From: Anita Gardner
Sent: 09 January 2019 10:06
To: Planning.Responses
Subject: FW: K/40/18/PL - Demolition of existing dwelling & erection of 1 No. dwelling, associated landscaping & parking (resubmission following K/11/16/PL)
Attachments: 247-D-02-REV-A.pdf; 247-D-00-REV-A.pdf; 247-D-12-REV-A.pdf

Re: K/40/18/PL - Demolition of existing dwelling & erection of 1 No. dwelling, associated landscaping & parking (resubmission following K/11/16/PL)

- D-00 Rev A (Site Location and Block Plan)
- D-02 Rev A (Proposed Site Plan)
- D-12 Rev A (Proposed North Elevation)

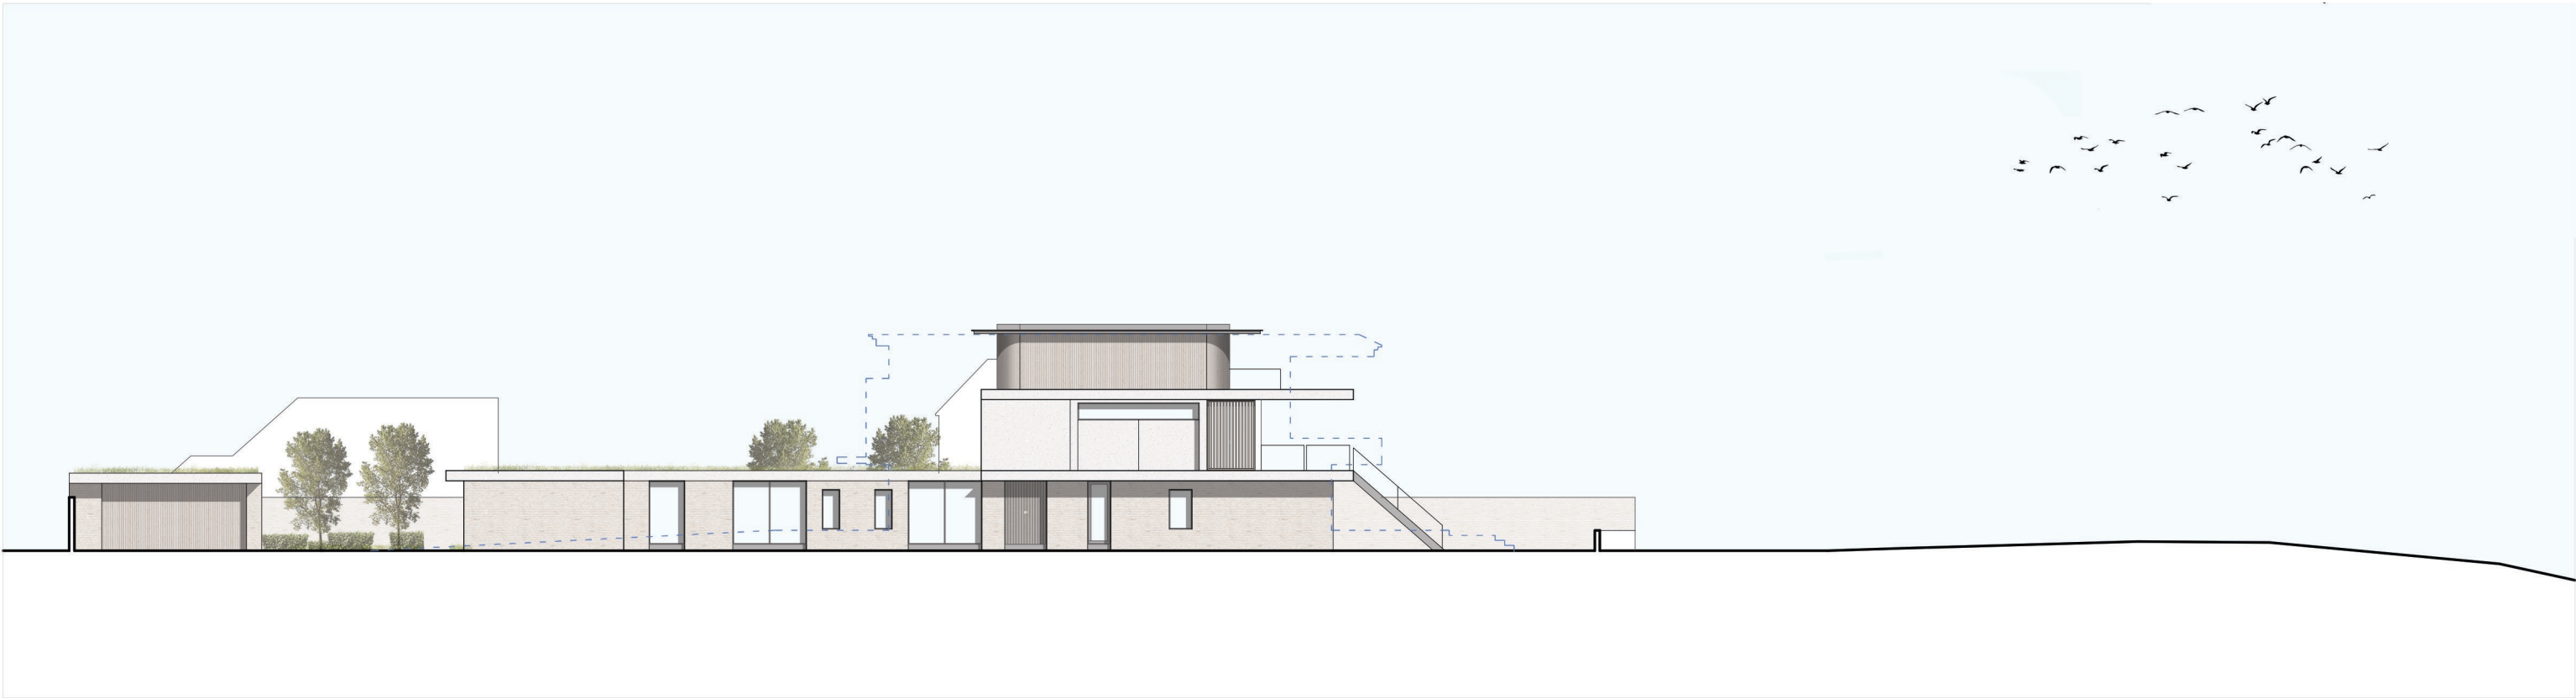
The proposal is only ever so slightly higher than the existing house and just marginally higher (100mm) than the 2018 permission for a new dwelling but it is **significantly** less impactful than the 2018 permission because of the shallow depth of the upper storeys (see attached application drawing D-17). This means that the impact of the proposal on the garden of *Mariners* will be very limited, in particular when compared to the extant permission. Indeed because of the siting of the main part of the building over the footprint of the existing house, there will be very little change from any shadowing that occurs at present.

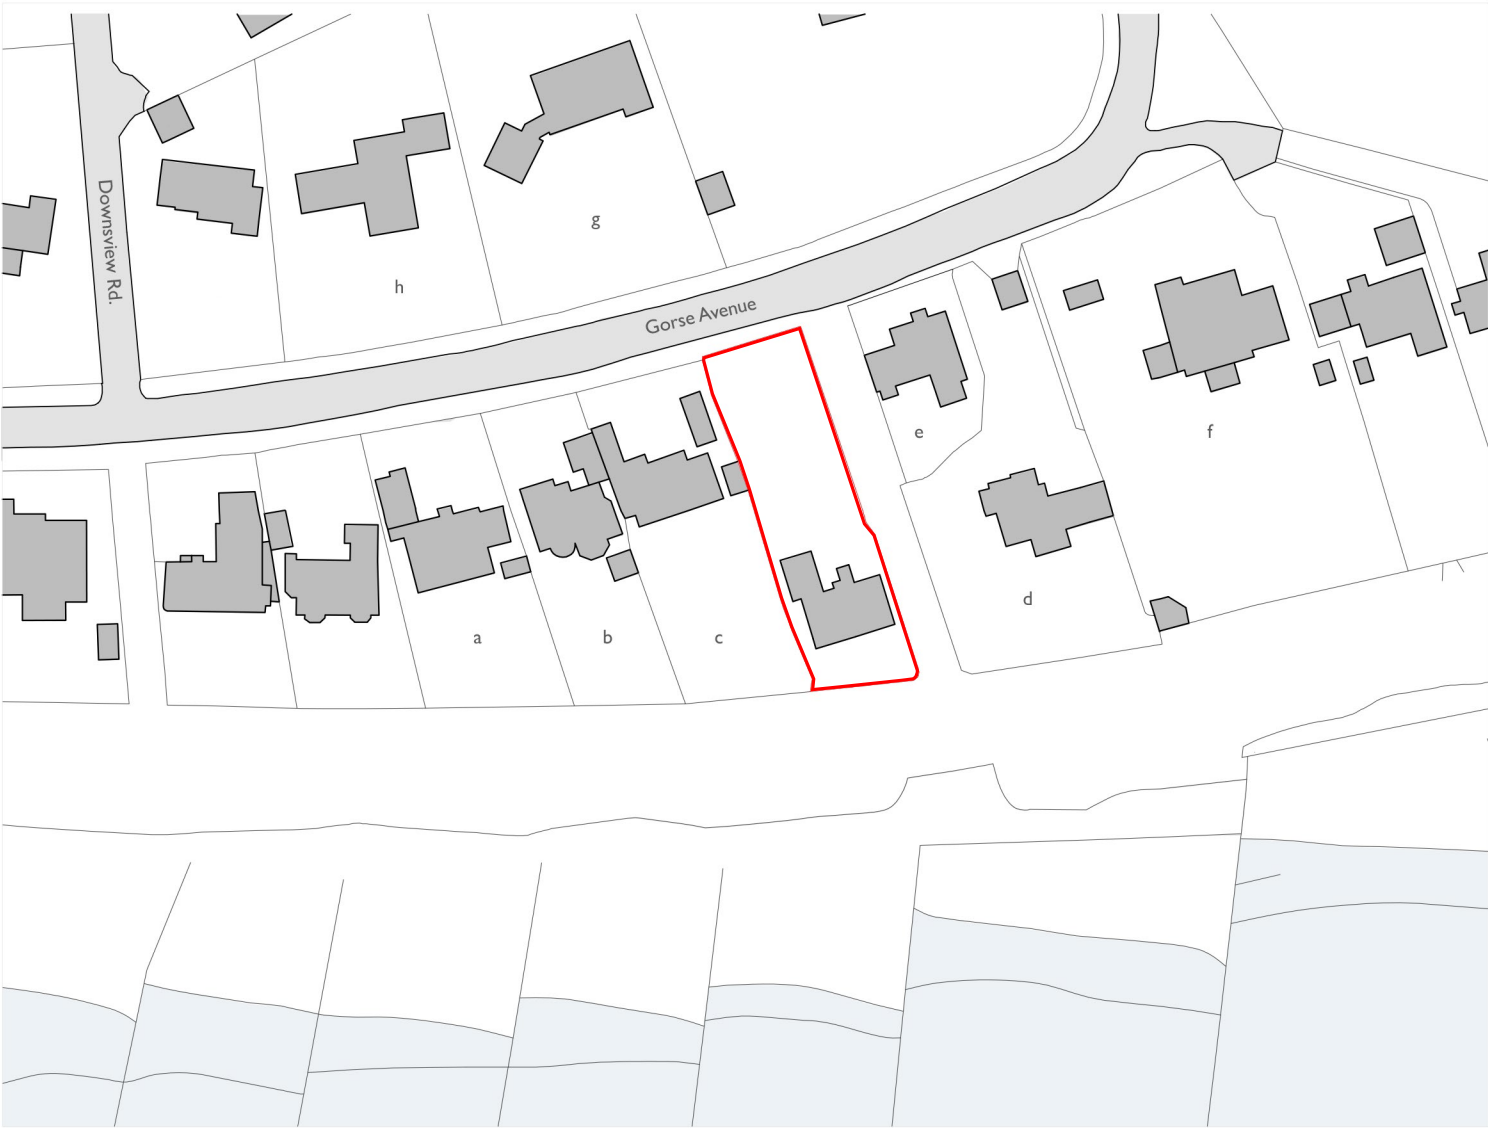
The Board have requested that we remove the detached garage to the front of the plot and that we make the North facing window to the 2nd floor obscured.

It is hoped that with the loss of the garage, the overall footprint of the proposal is now acceptable to the Board. Whilst the single storey element stretches back towards the front of the plot, there is now no development along the front boundary and the ‘internal garden’ that is bounded by the single storey element is complimented by green roofs which soften the appearance of this part of the development from the only point it can be fully perceived, ie from the upper storeys of the neighbouring properties.

Drawing: Proposed North Elevation
Dwg No: 247-D-12-REV-A

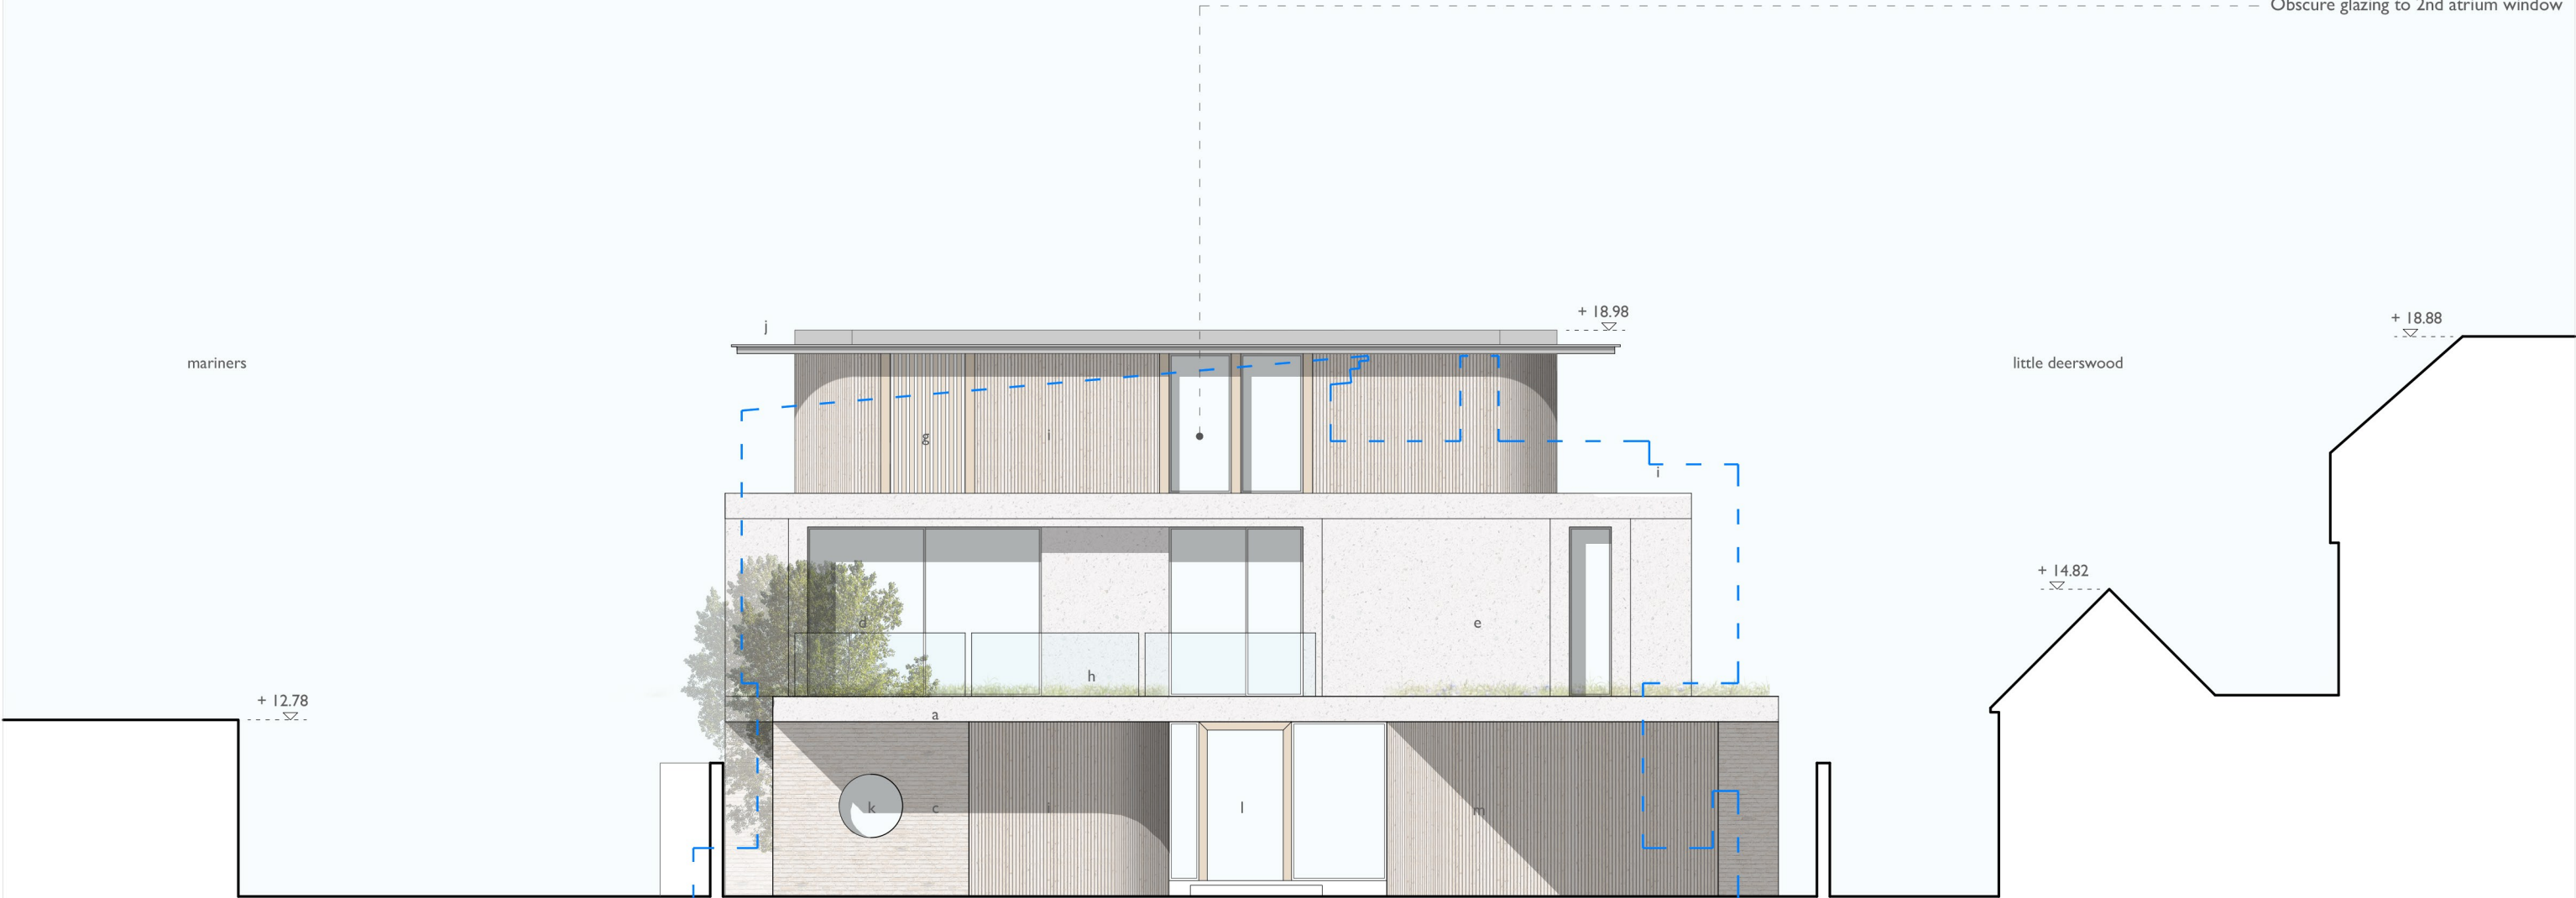
The window at 2nd floor looking to the North over Gorse Avenue is set a full 30m away from the property *Westwood*, and as we discussed on site, the views out from this window are limited as it opens out from an atrium space. However should there be a concern with the impact of this window on the houses to the North, we would be pleased to propose this as obscure glazing.
